Our Ref: R/2019/2/F  
File No: 2020/539313  
Your Ref: SSD 9835 – MOD 2

**Response to Submissions – Modification 2 Stadium Members Facilities – Sydney Football Stadium (SSD 9835)**

Thank you for your correspondence dated 17 November 2020 requesting for the City of Sydney Council (“the City”) to comment on the Response to Submissions (RTS) for the Sydney Football Stadium (SFS) Stage 2 development. The proposal relates to a modification involving the detailed design, construction and operation for new Stadium Fitness Facilities.

DRAWING
PLANTING PLANS
Ground Level - Quad C

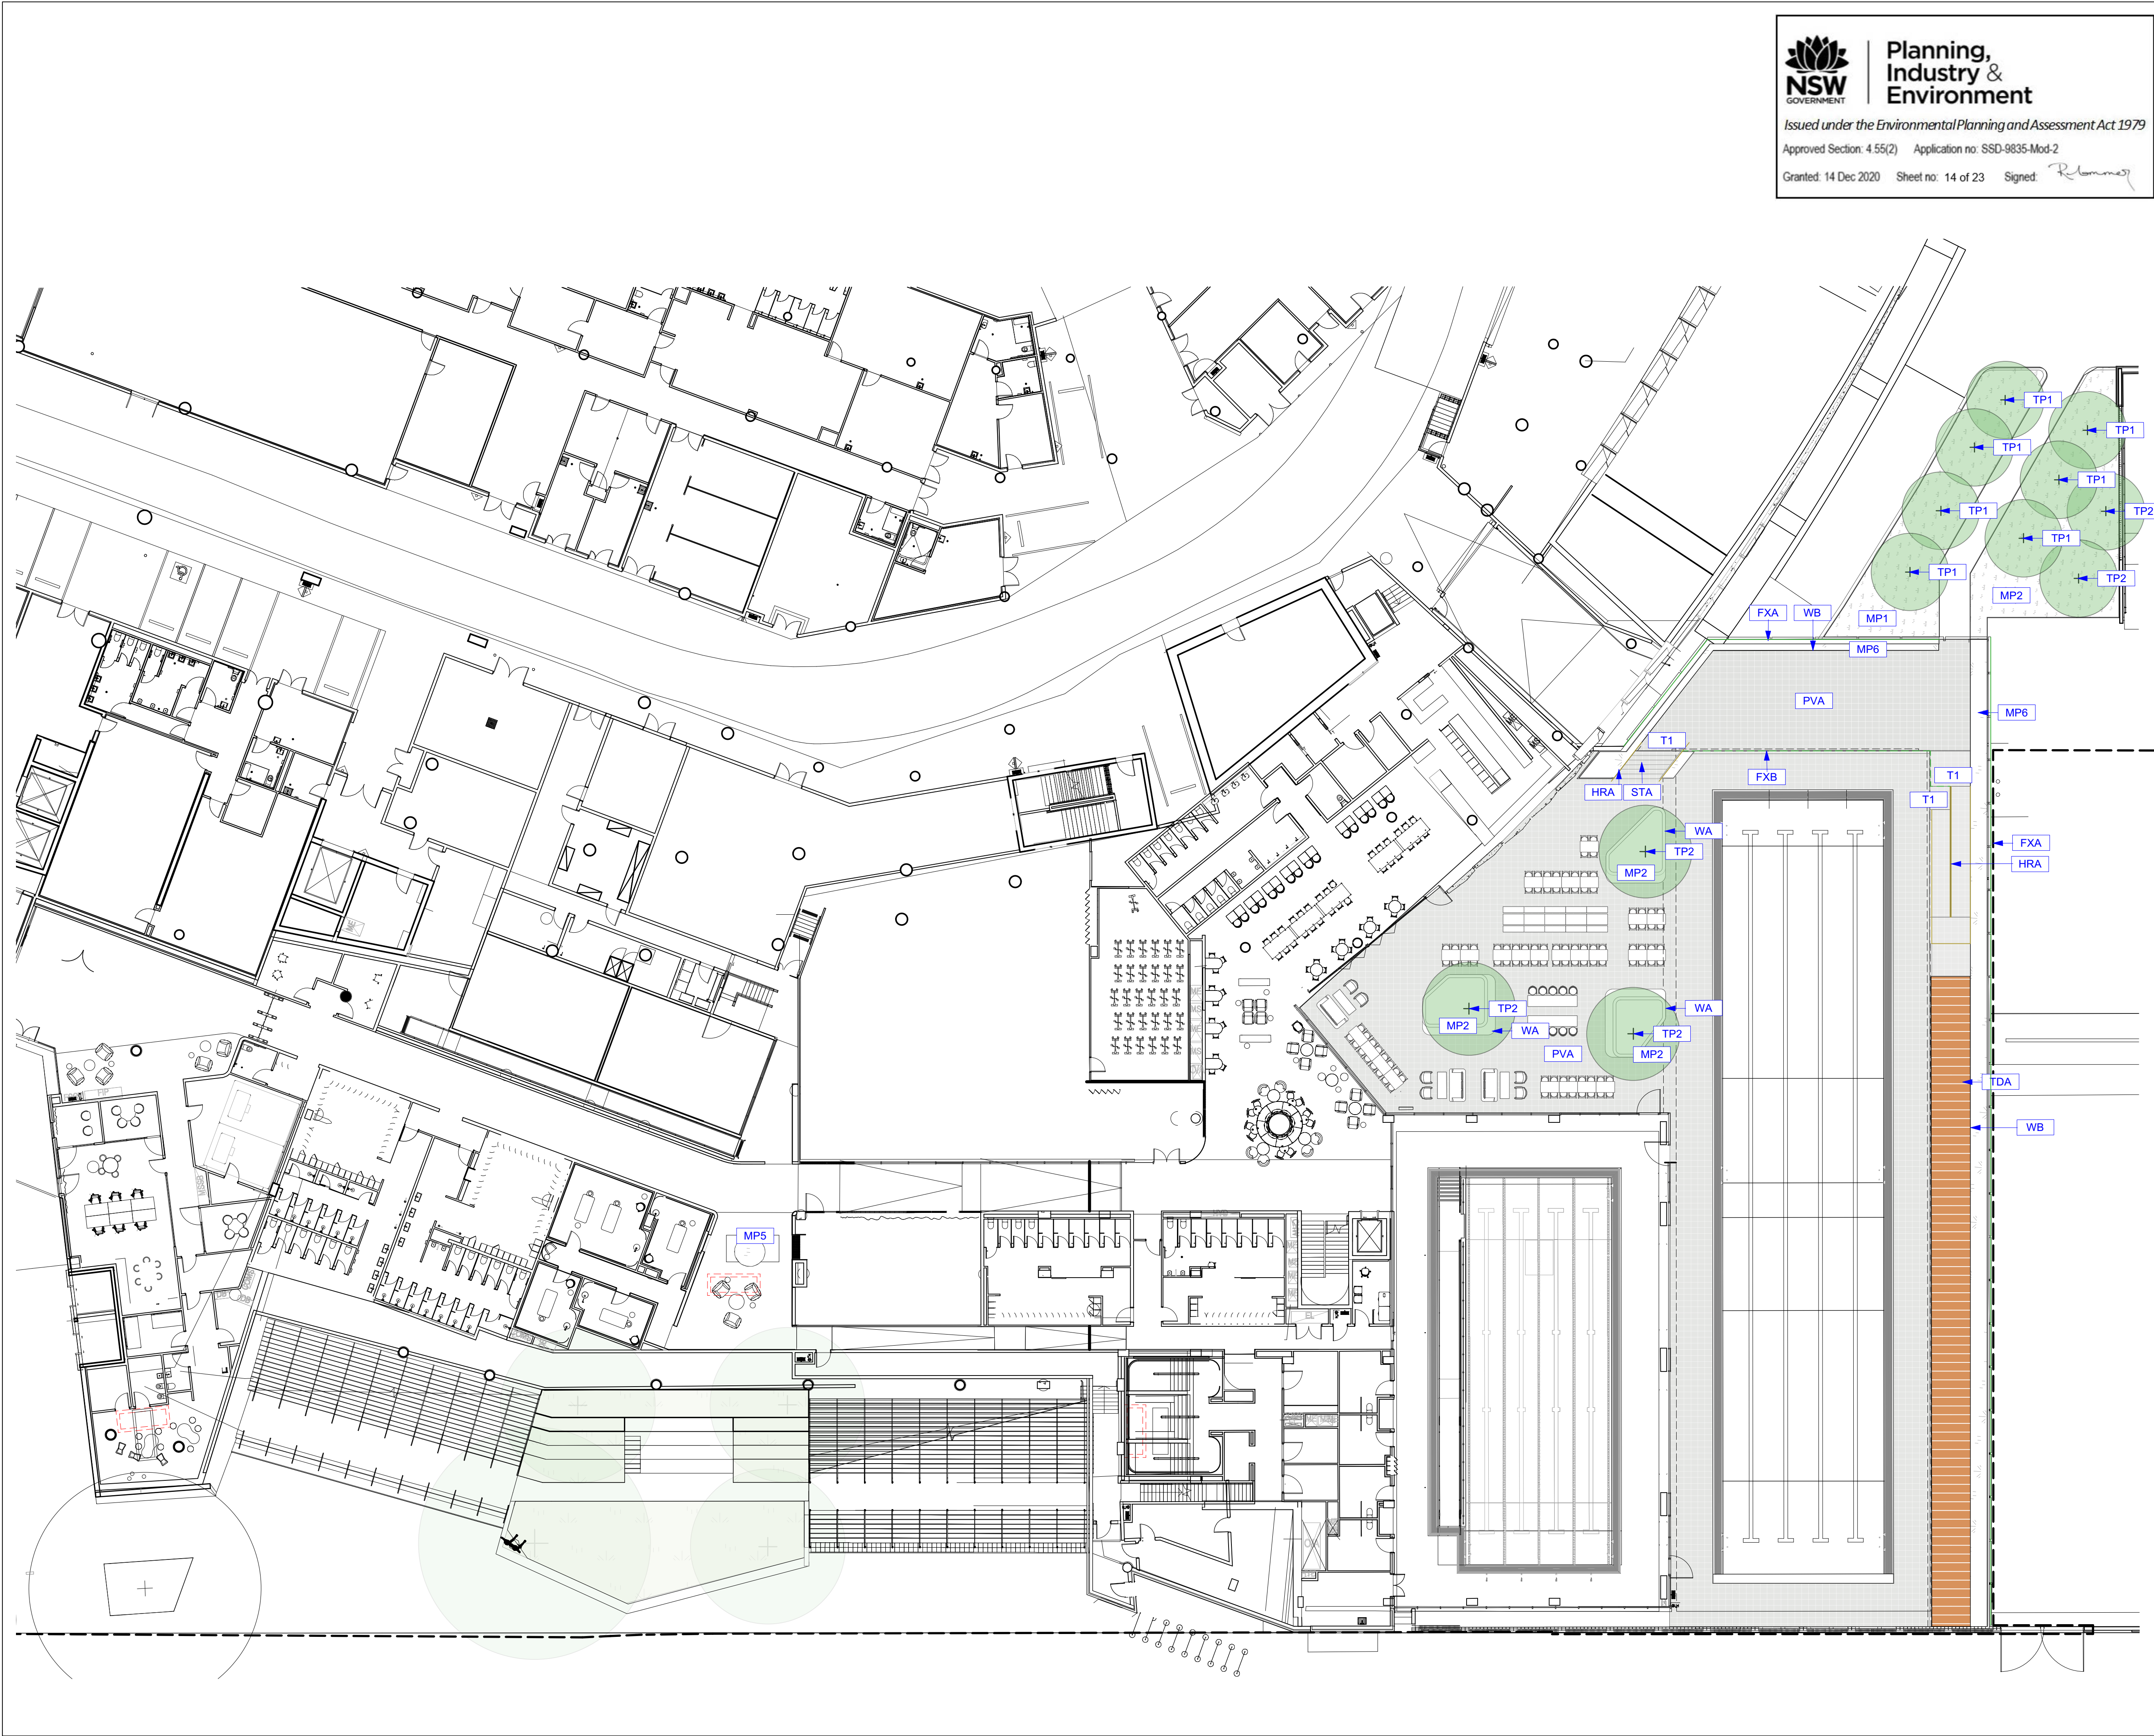
The landscaping proposed within the pool deck and cabana zone include two trees *Cupaniosis anacardioides* (Tuckeroo) that are proposed to be relocated from the southern abutment landscape to the eastern edge of the pool courtyard. It is unclear why these trees have been relocated. Nevertheless, it is recommended that all planter boxes and planting on slab in the eastern courtyard be designed to provide adequate soil depth and volume for trees and palms, screening hedges, mass planting and turf. The use of artificial turf is not supported not only for its artificial plastic nature, but contribution to significant heat loads in summer months. Any turfing is to be designed using natural turf.

The landscape design and plant schedule are to be amended to employ hardy native species with a preference for drought resistant species that contribute to habitat creation and biodiversity. Overall, the landscape package is to provide further detail to public domain material schedules and plant schedules as well as details for all planters, planting on slab, green roofs and internal planting.
